Council Reference: DA10/0222.26 LN44549
Your Reference: MP06_0258 MOD 10

Comments on the proposed modification - amendment to Casuarina Town Centre including 56 lot subdivision, road works, infrastructure works and landscaping (Department of Planning Application MP06_0258) MOD 10 at Lot 13 DP 1014470; Casuarina Way CASUARINA; Lot 144 DP 1030322 & Lot 144 DP 1030322 & Lot 3 DP 1042119; Tweed Coast Road CASUARINA

Assessment of Modifications Proposed as Part of this Application

Figure 3-1 Concept Details of Retaining Wall At Transition From Swale To Pipework

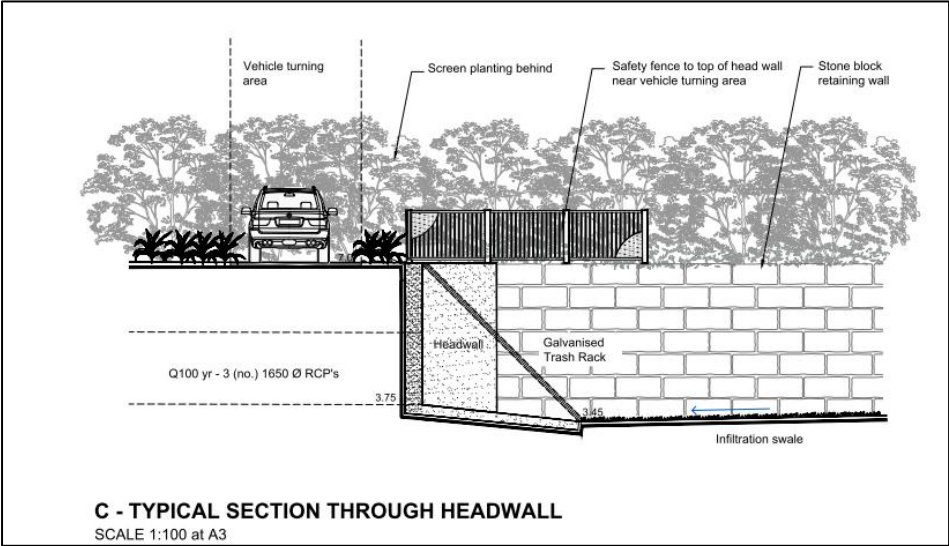
Concerns are raised with respect to the extent and number of retaining walls proposed under the modified layout. Council's Development Engineering Unit has advised the following with respect to this;

- Tweed Shire Councils Development Design Specification – D6 Site Regrading (TSC-D6) specifies that the maximum permissible combined of retaining walls or batters in residential subdivisions shall be 1.8m above street level and 2.4m below street level. The proposal to have a retaining wall up to 4m in a residential subdivision (adjacent to proposed Lot 92) does not comply with TSC – D6.
- Concerns are raised on the number of retaining walls proposed across the site. It seems that the applicant has used multiple retaining walls to provide flatter gradient sites. The previous earthwork approvals did not have multiple retaining walls and still achieved compliant gradients.

TYPICAL CROSS SECTION GRAND PARADE

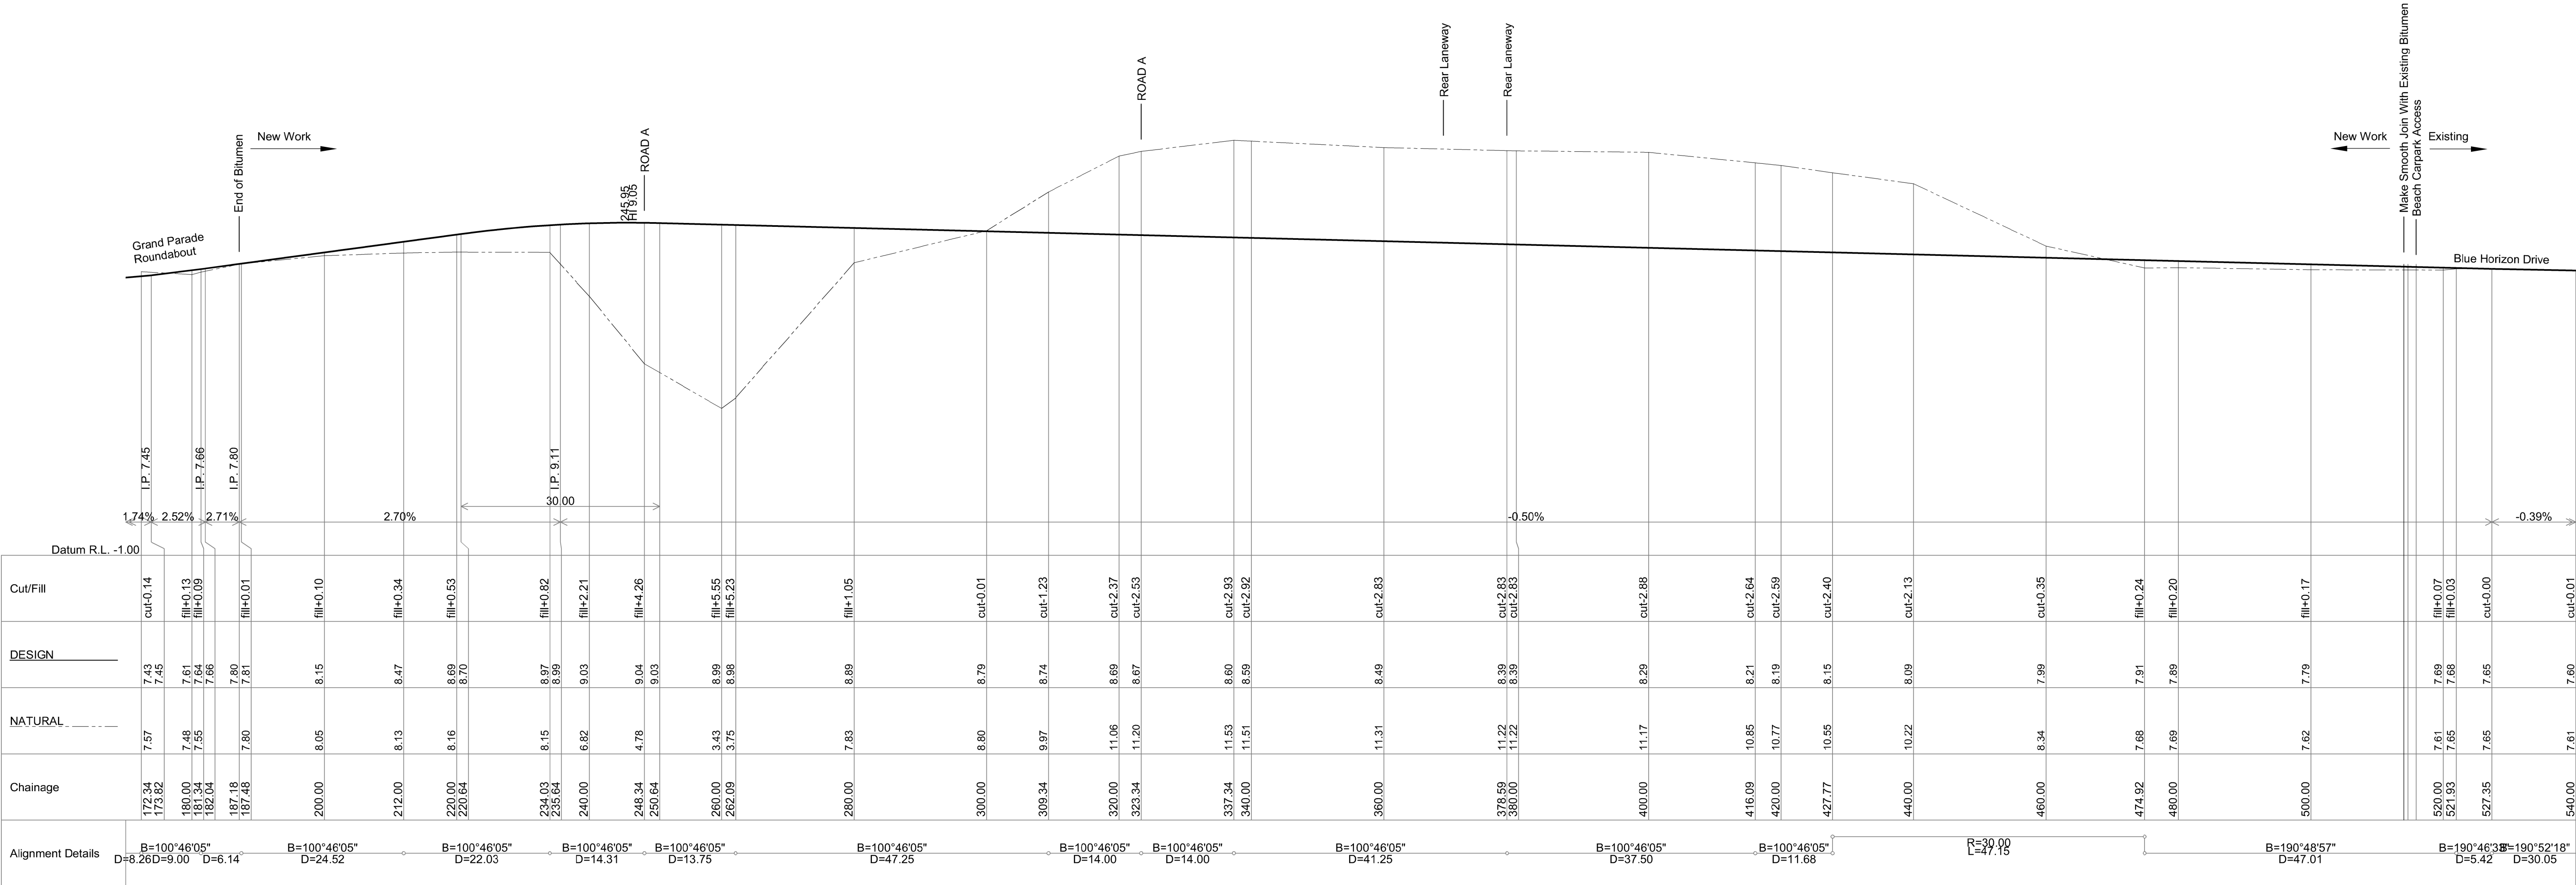
- *The modification now seeks to reduce the road reserve width of Road 1 (Grand Parade) from 33.370m to 29m in width. The modification also is reducing the verge area from 4.5m to 3.5m. Tweed Shire Councils minimum road reserve width for this type of access road is to be 30m and minimum footpath verge to be 4.5m.*

- *The applicant is to indicate if the mixed use will provide shop frontage on Grand Parade and if so then Tweed Shire Council standard road standards require full width concrete pavement of the 4.5m wide verge on Grand Parade.*

LEGEND

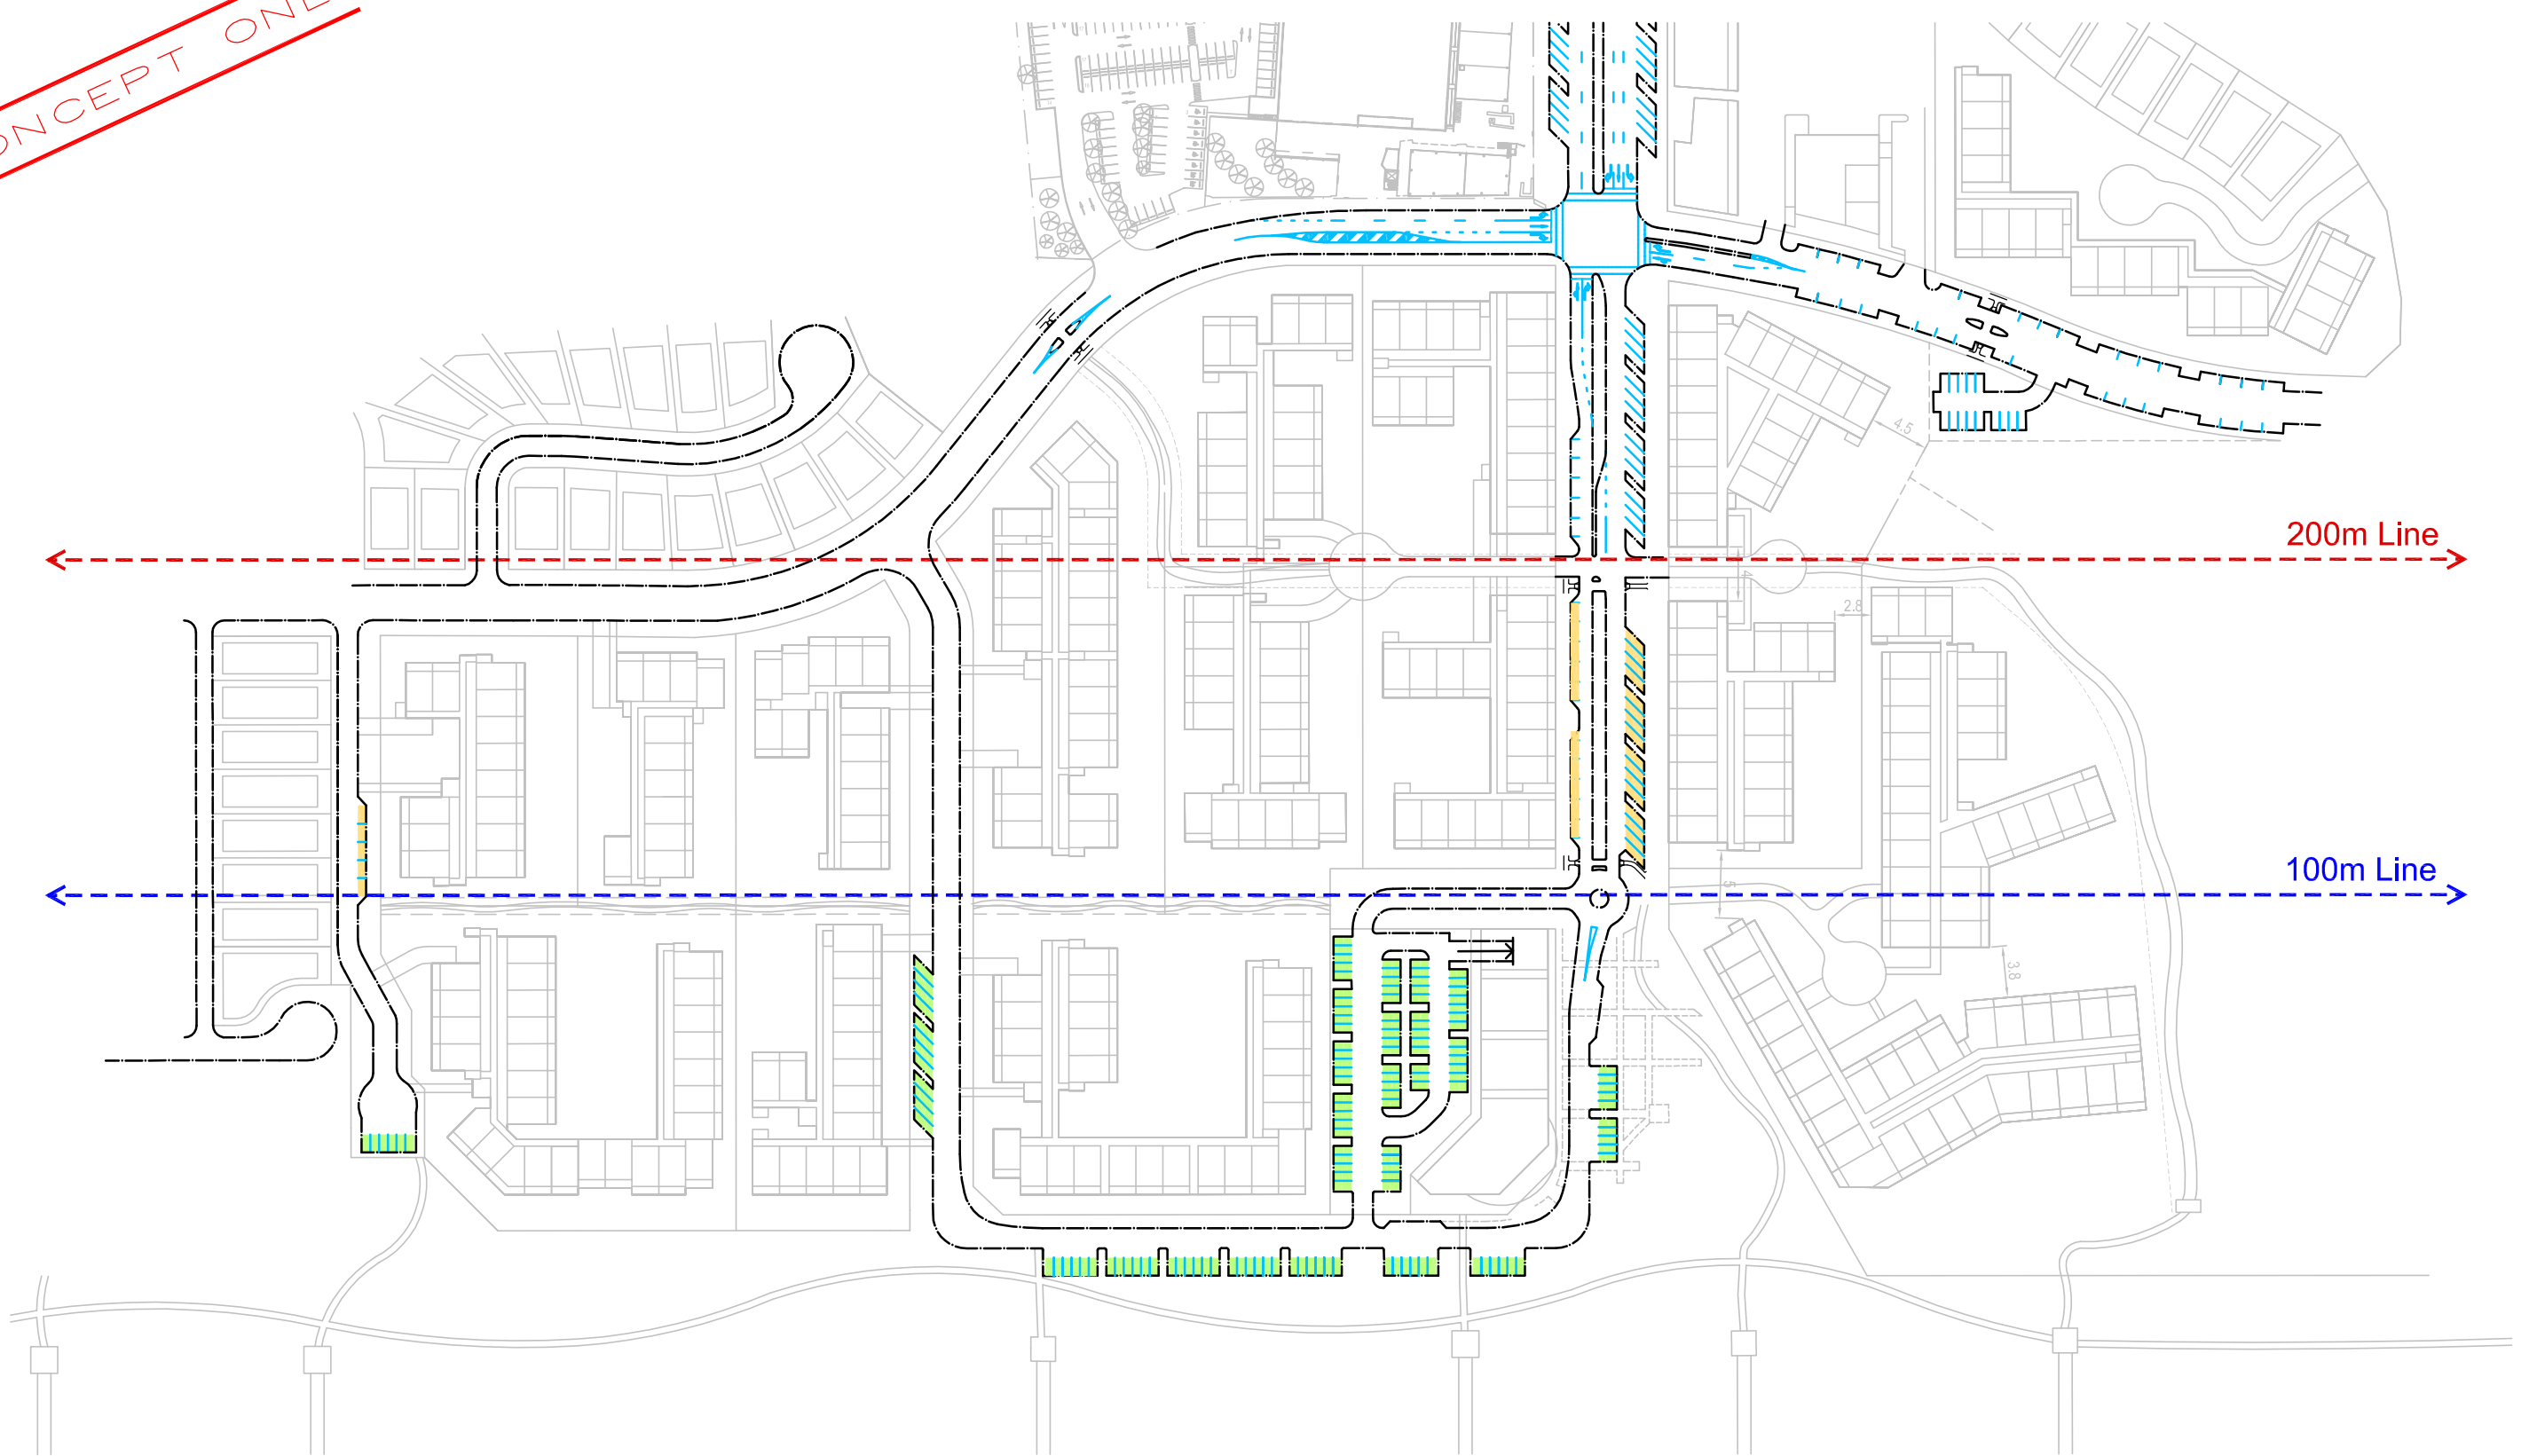
- *Additional 17 existing car parking spaces are counted as being within the 100m zone. Upon review of car parking counts it seems only 6 to 7 car parks*

are within the 100m zone. Applicant to demonstrate how 17 car parks were counted as part of the 100m zone.

- *The total car parking calculations does not take into consideration the three (3) car parking spaces removed as agreed for the Kool Kids development.*

- *The proposal is essentially re-locating the existing approved car parking along Blue Horizon Drive (existing 42 parks – proposed 14 parks) to Grand Parade. Upon re-locating the car parks the applicant is changing the car parking layout from 90 degree parking to parallel parking. By re-locating the majority of car parking to Grand Parade concerns are raised regarding the following:*

- 1) *Reduction in car parking within the 100m beach parking zone by approximately 24 car parks.*
 - 2) *The car parks in Grand Parade is more focused on mixed use (shop) car parking rather than public beach car parking.*

- 3) *The mixed use development (shop) will want to use the public car parks in Grand Parade as credit provisions in their car parking calculations (similar to the Seaside City development).*

- 4) *The parallel parking along Blue Horizon Drive is essentially not providing additional car parking given commuters would most likely park on the side street. The car parking proposed is only formulating car parking spaces. It is preferable if 90 degree parking is provided as per the original approval.*

- 5) *Angle parking 30 – 60 degrees is not supported in Grand Parade in this instance as it would restrict users on opposite side of road to park. Previously there was a median proposed down the centre line of Grand Parade and 30 - 60 degree parking was desirable given one sided traffic lane. As there is no proposed central median preference is for 90 degree parking to be provided in Grande Parade to allow both east and west commuters to park.”*
